**WELWYN HATFIELD BOROUGH COUNCIL
EXECUTIVE DIRECTOR - PLANNING, PUBLIC PROTECTION AND GOVERNANCE**

DELEGATED APPLICATION

Application No: 6/2020/1745/HOUSE
Location: 6 Hill Rise Cuffley Potters Bar EN6 4EE
Proposal: Erection of first floor front extension, alteration of roof form into crown roof, part single part two storey rear extension, alteration of fenestration and insertion of first floor side windows into the western flank elevation wall.
Officer: Mr Antoine Commenville

Recommendation: Granted

Date:	14 April 2020
Scale:	A1@1:100
Dwg:	030/20 4
Drawn by:	SA

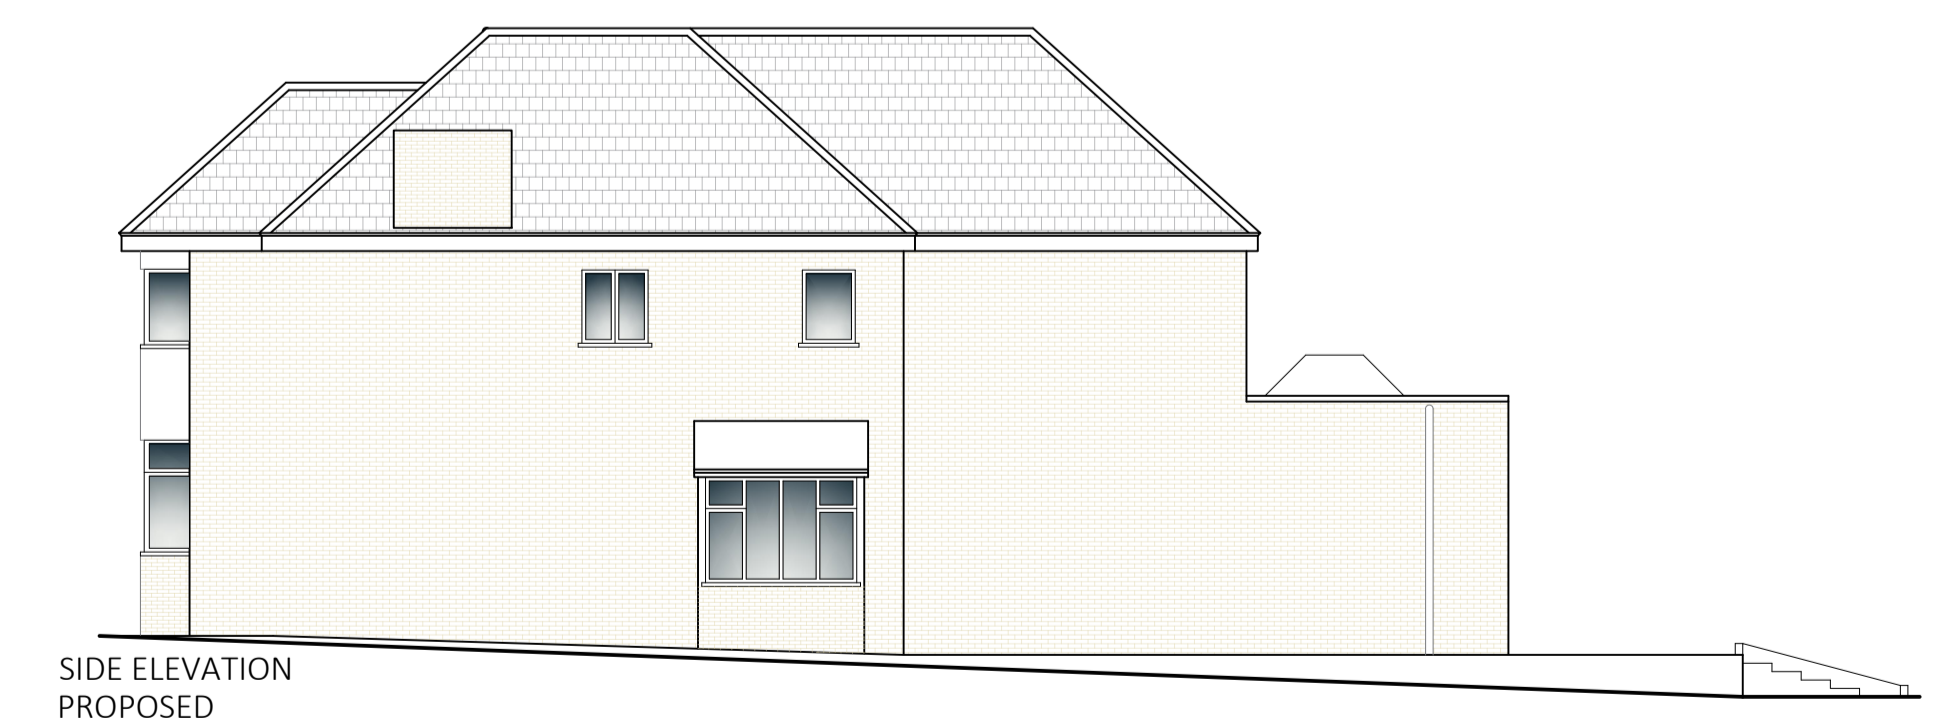
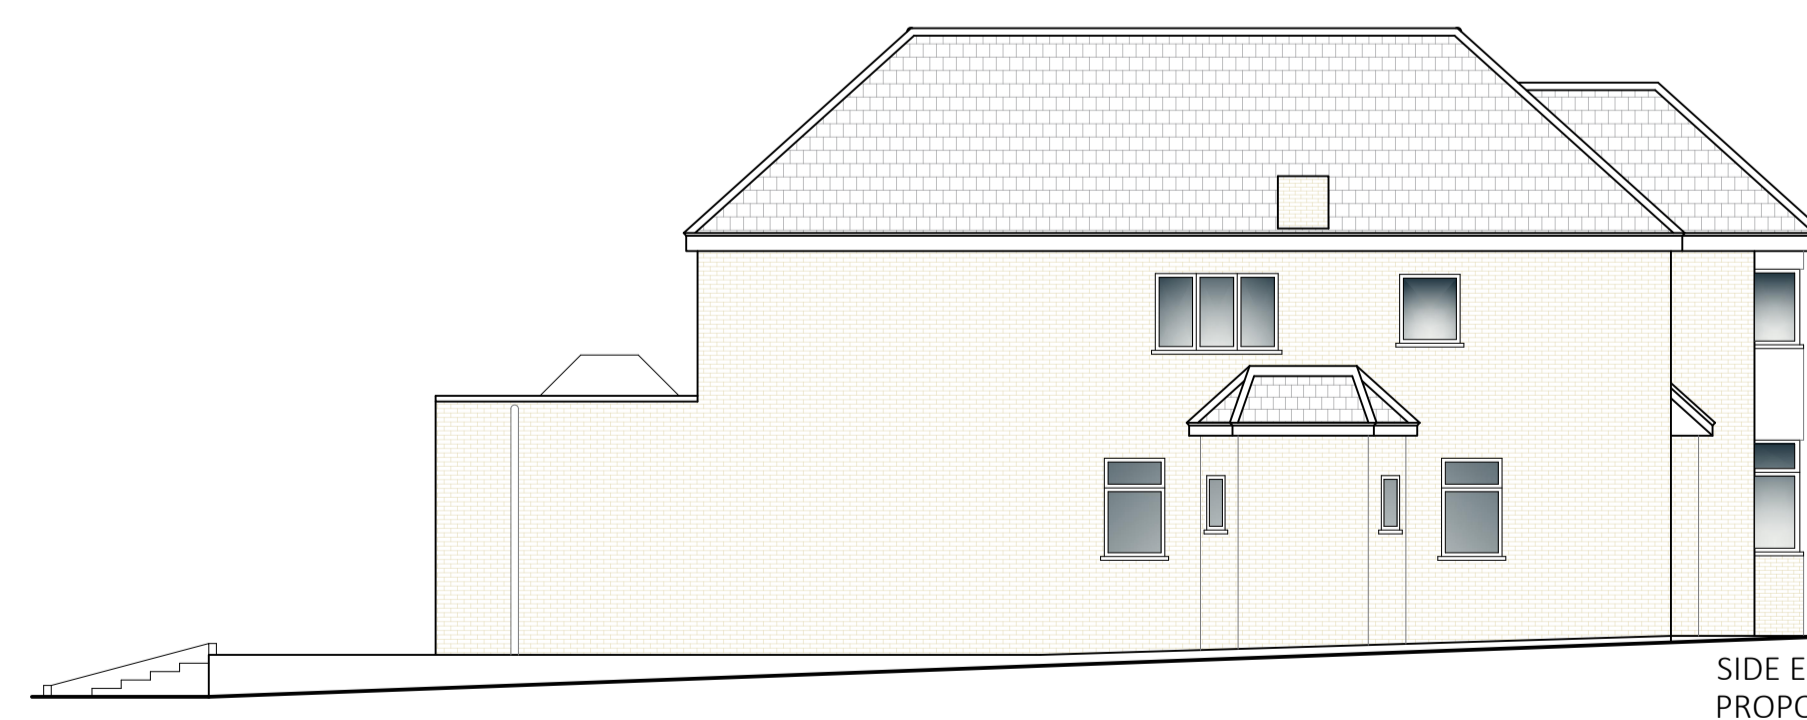
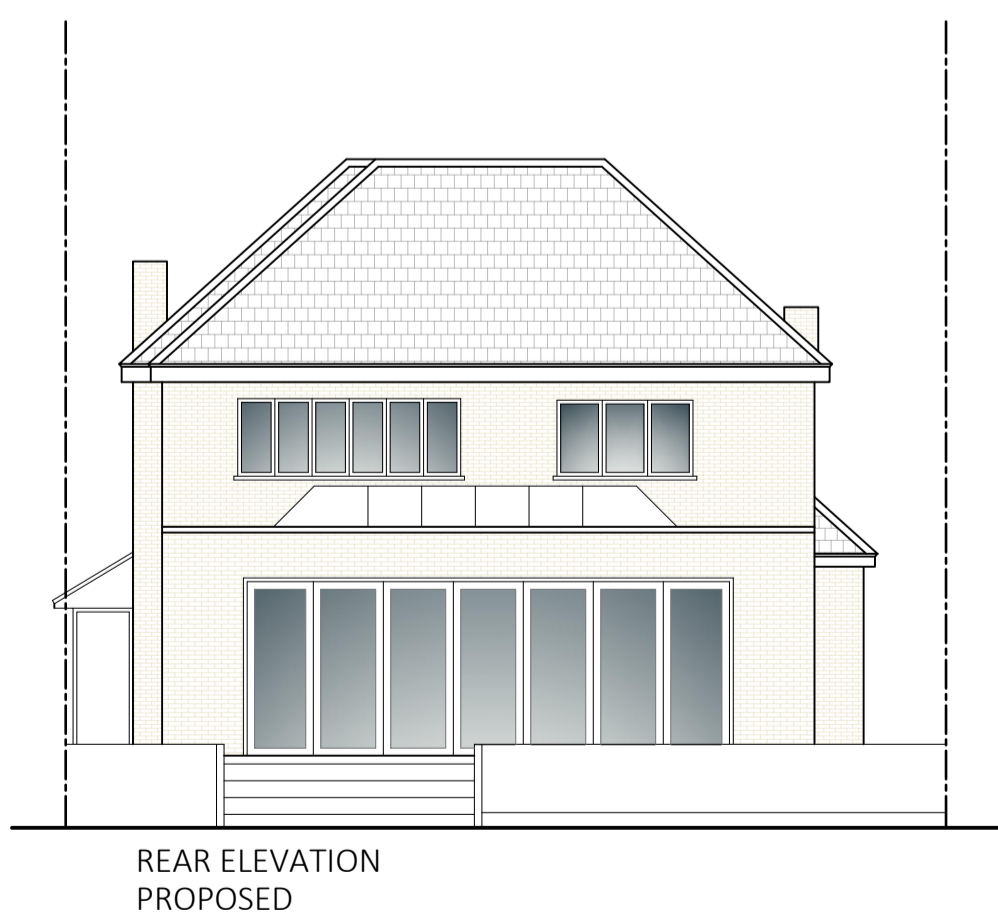
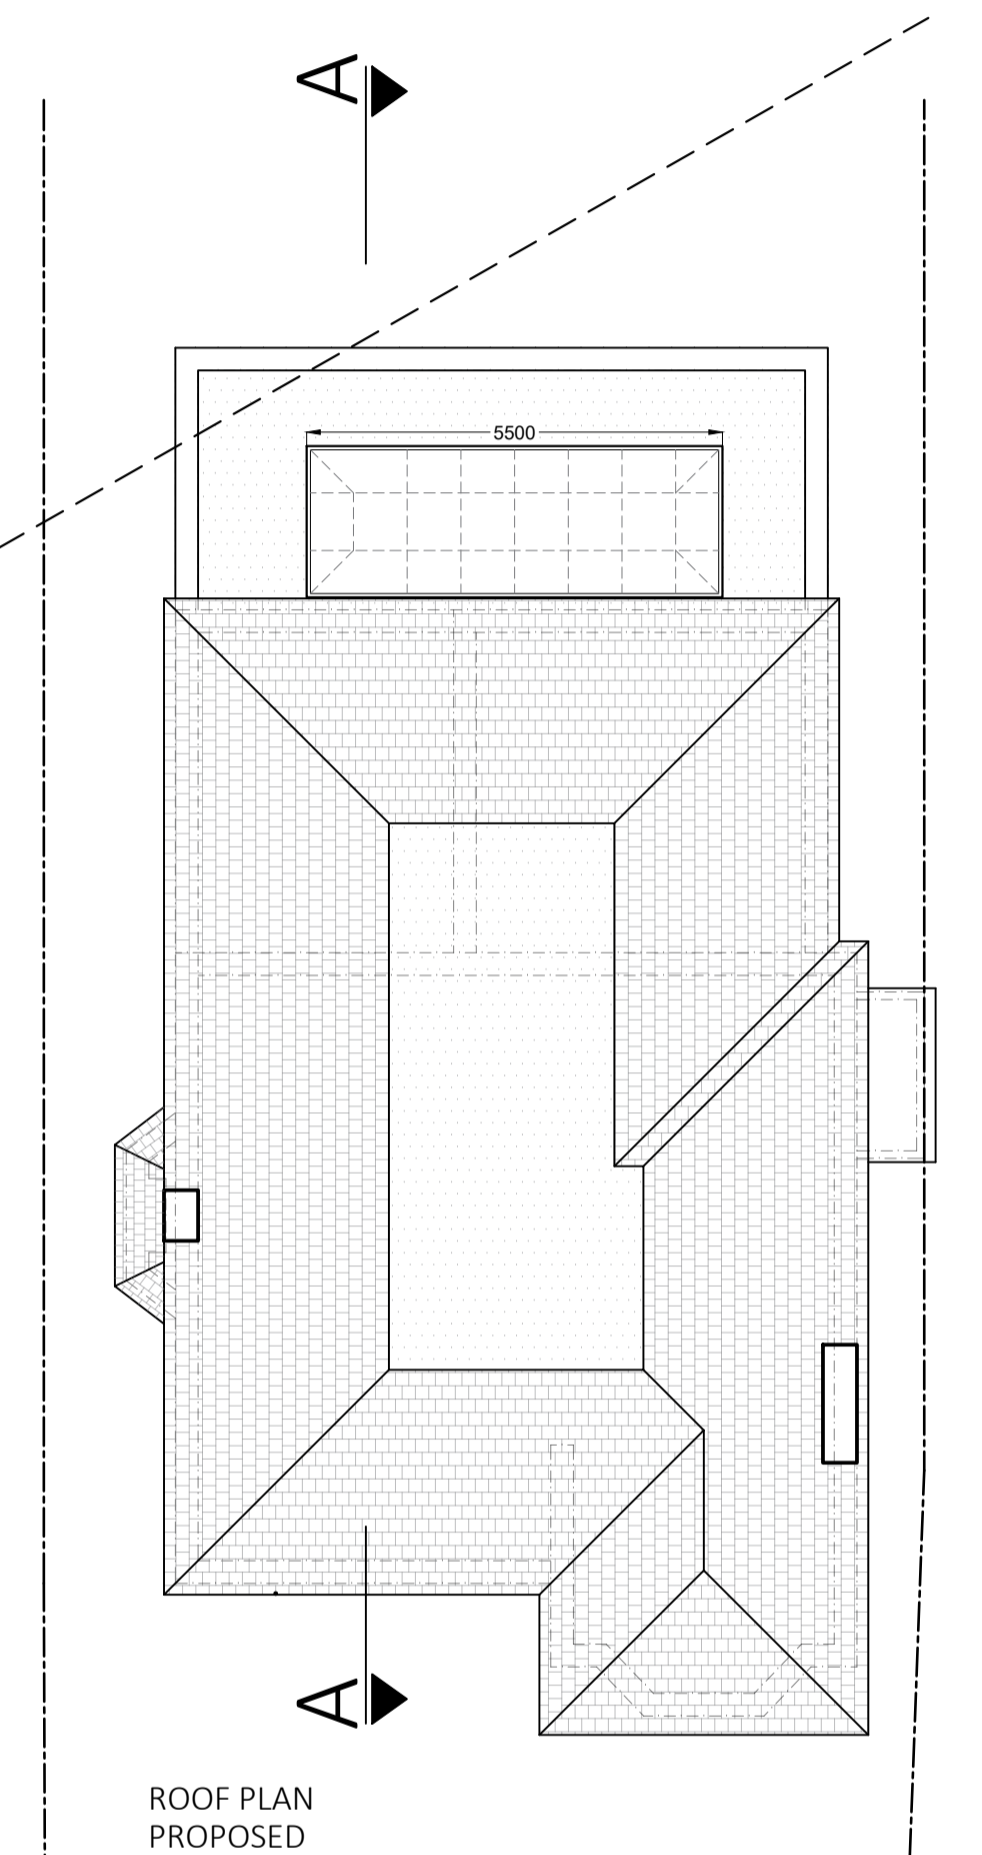
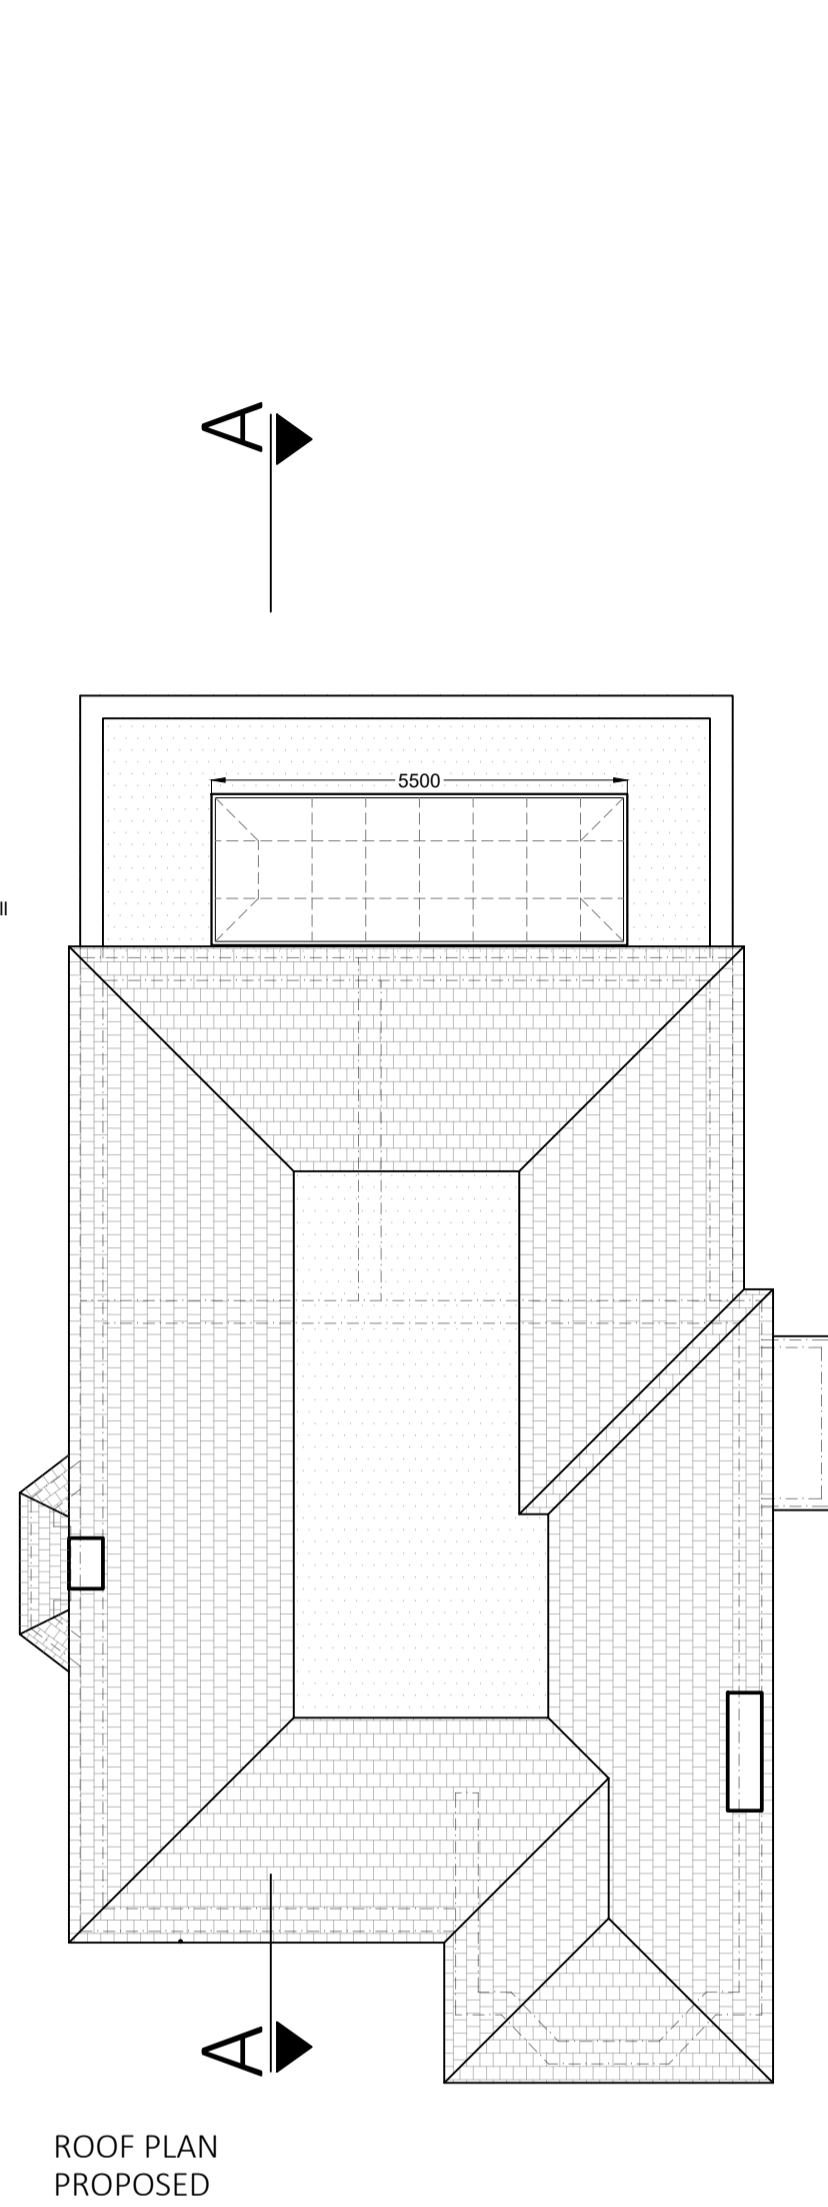
Comment (if applicable): A first floor flank window is proposed to be inserted within the western

flank elevation wall at first floor level and facing No.8. It is considered reasonable to add a condition for this window to be obscure glazed and non-opening below a height of 1.7 metres when measured from internal floor level to ensure that the windows would not result in any overlooking or a loss of privacy to No.8. However, this window is the only window serving this bedroom which is not ideal. However, this would be the only bedroom out of 4 proposed bedrooms to be served with obscured glazing only and it is therefore considered to be acceptable.

3. Any upper floor window located in a wall or roof slope forming a side elevation of the building hereby approved must be obscure-glazed and non-opening unless the parts of the window which can be opened are more than 1.7 metres above the floor

of the room in which the window is installed, and shall be retained in that form thereafter.
